**Application for Works to Tree(s) on trees subject to a Tree  
 Preservation Order (TPO)**

**DECISION NOTICE**

Application Ref: BR/180/15/T

Reduce 1No. Holm Oak by 4 metres

Figure 4 Diagrammatic illustration of crown reduction

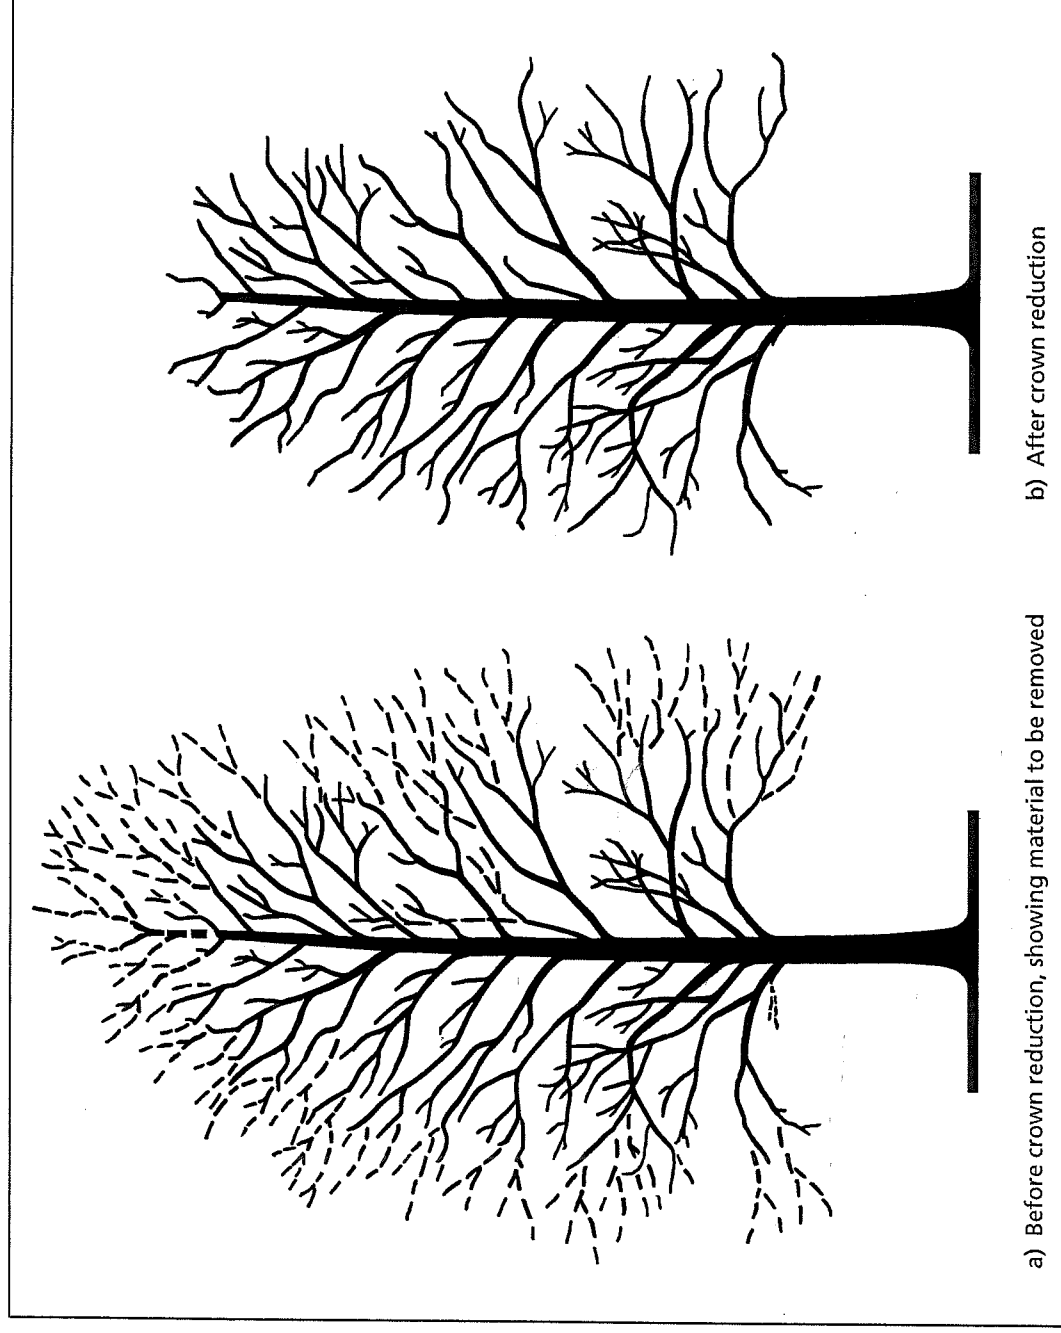
- 1                      The reduction by 4m exceeds the established 3.5m pruning points for the tree and as such the reduction is excessive and unnecessary and not consistent with good practice and tree husbandry.

INFORMATIVE: The application should be revised to propose a reduction of no more than 3.5m (established pruning points) in order to be acceptable.
